About the application

Application number: 2023/91795	
What is the application for?:	Erection of two storey side extension and new porch with associated alterations
Address of the site or building:	2, Enfield Drive, Carlinghow, Batley, WF17 8DY
Postcode:	WF17 8DY

Type of comment: An objection	
Do you wish your comments to be published on the website anonymously?	Yes

FRONT

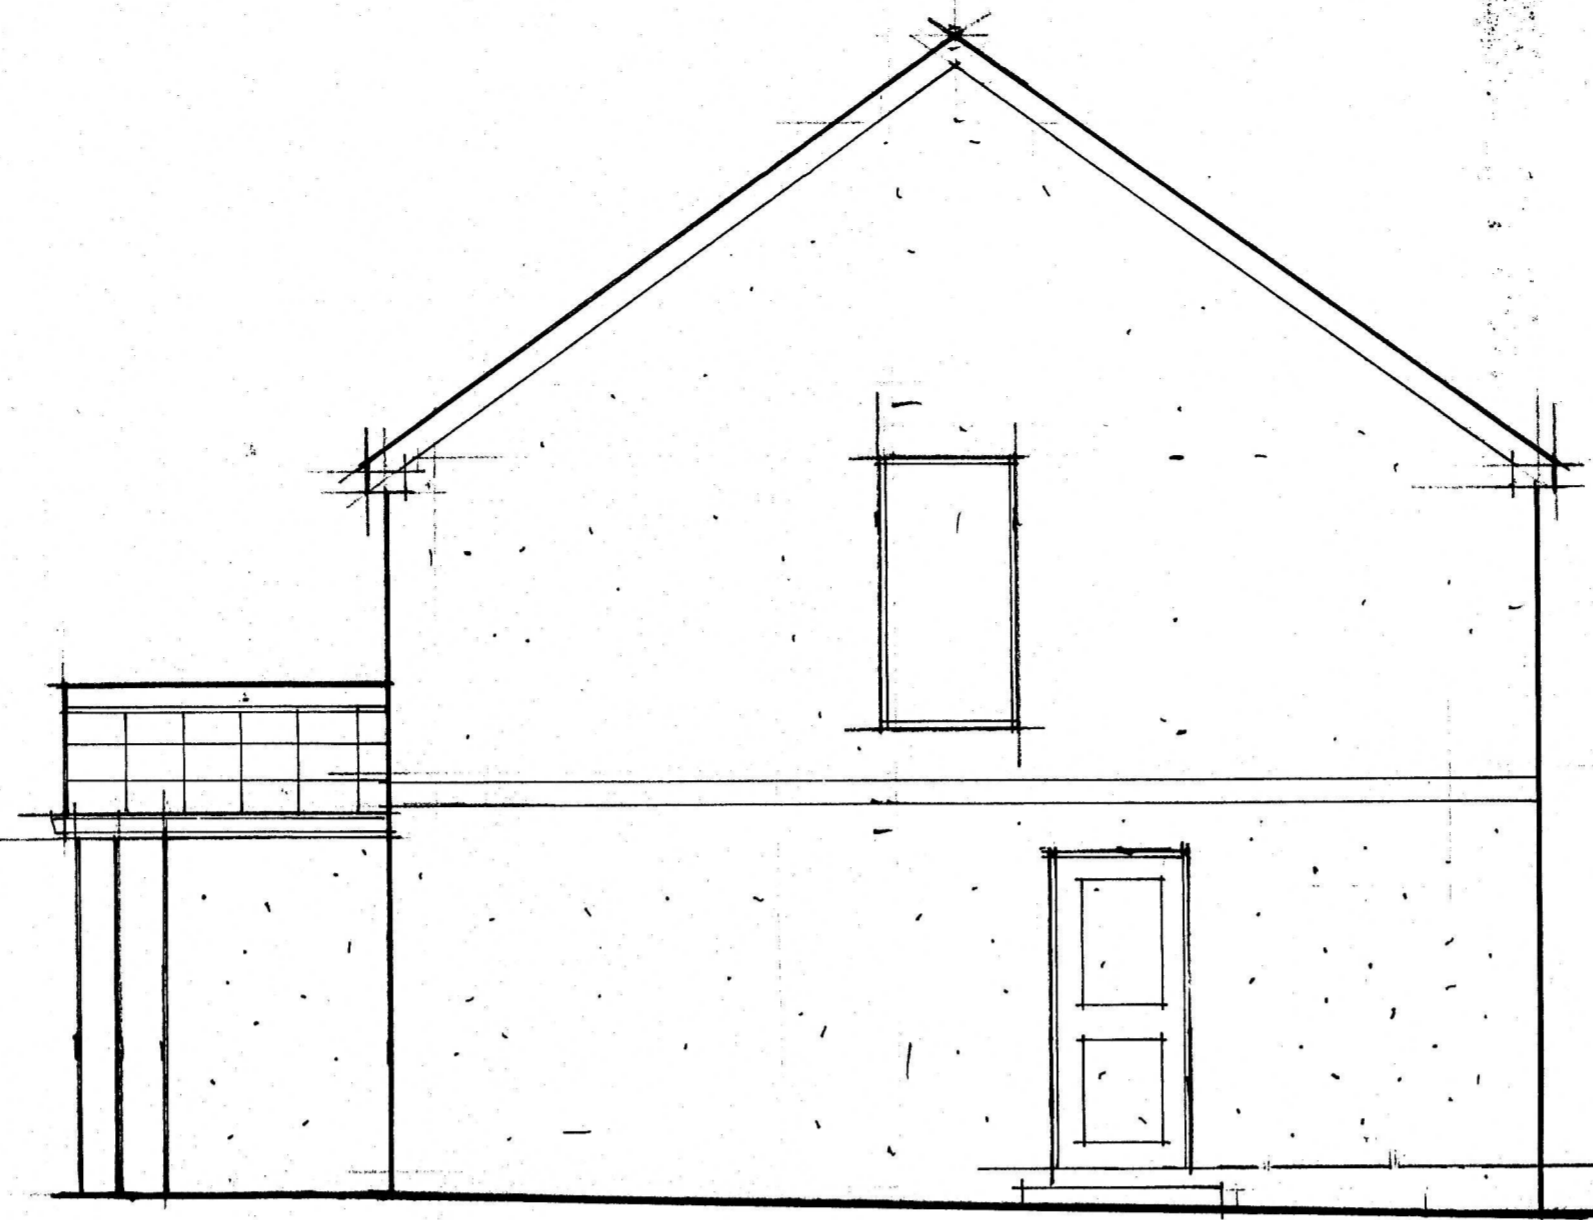
Also item 5.20 guidance suggests— 2 storey extensions should be set back a minimum of 0.5m from the front wall of the house. To provide minimum street impact.

GROUND FLOOR

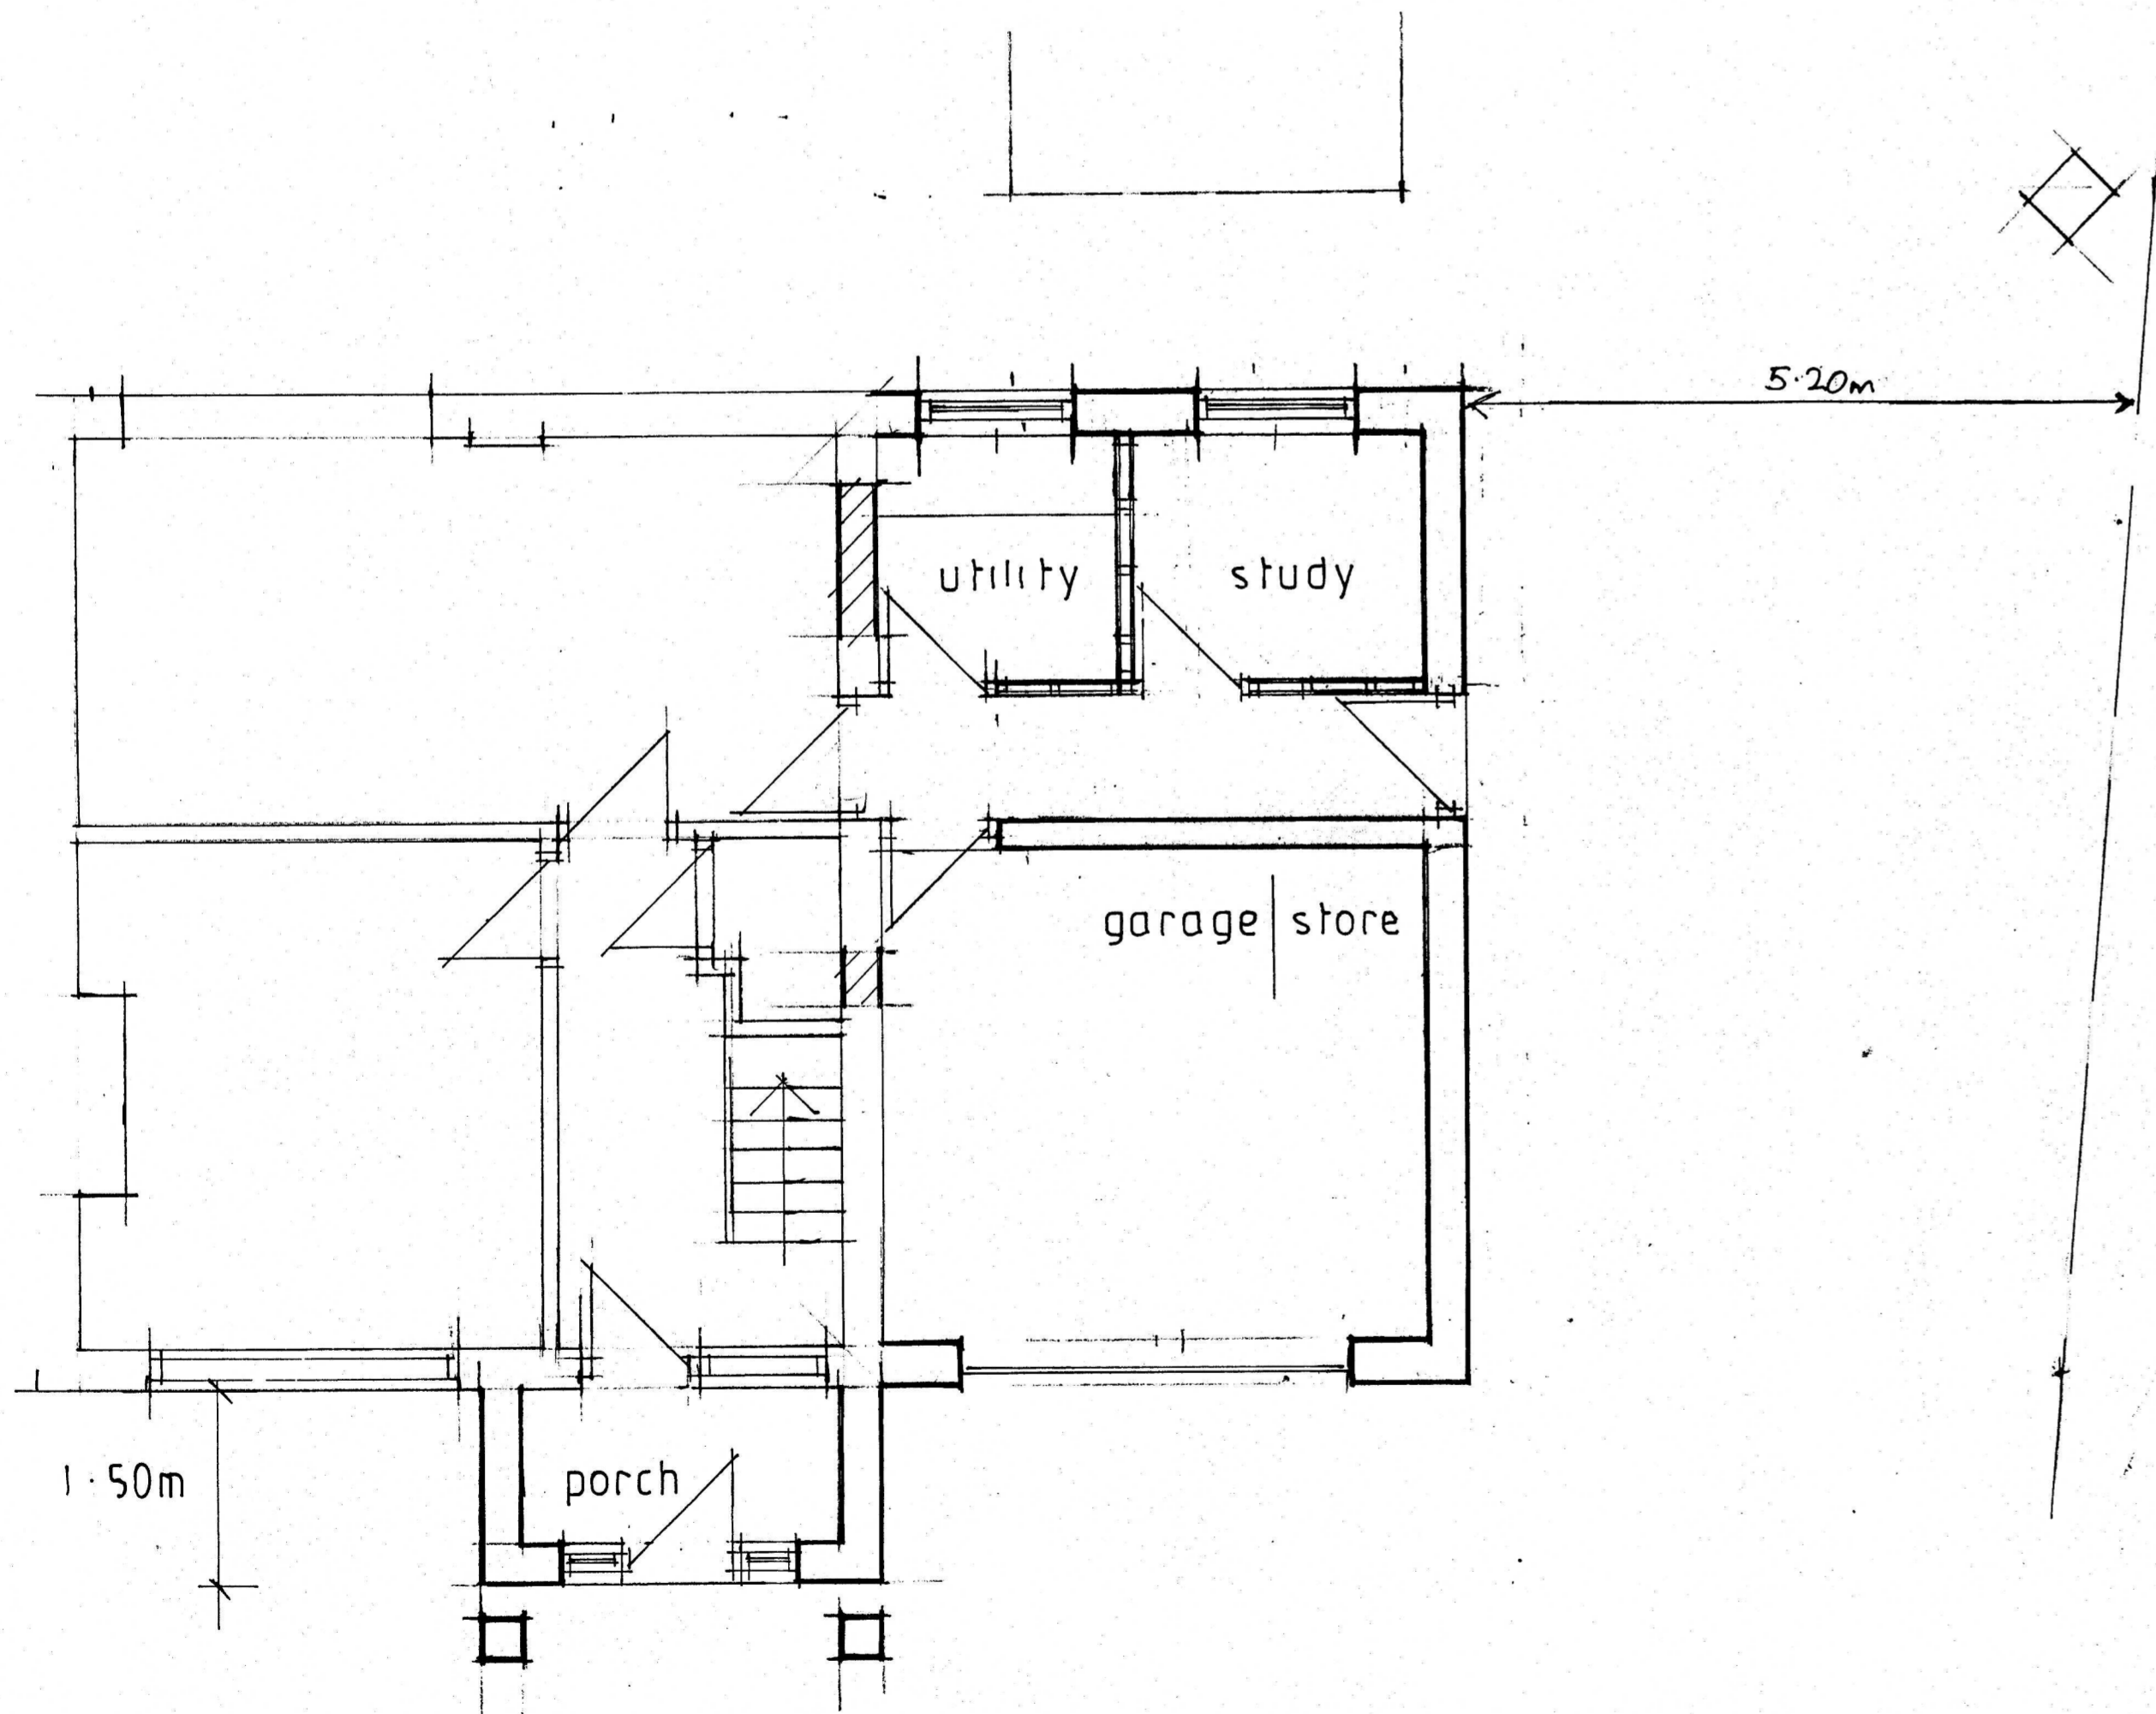
The proposed extension has reduced parking provision within the curtilage.

Existing property has 3 bedrooms/provides 3 parking places.

Proposed extensions has 5/6 bedrooms,proposed 2spaces.

The proposed new garage indicates an internal width of 4.65m.

If this was increased (0.35 m)slightly to 5.0m with a full width access garage door and the corresponding drive likewise,2 vehicles could be parked in the garage and1/2 vehicles in the drive and would provide the appropriate off street parking.
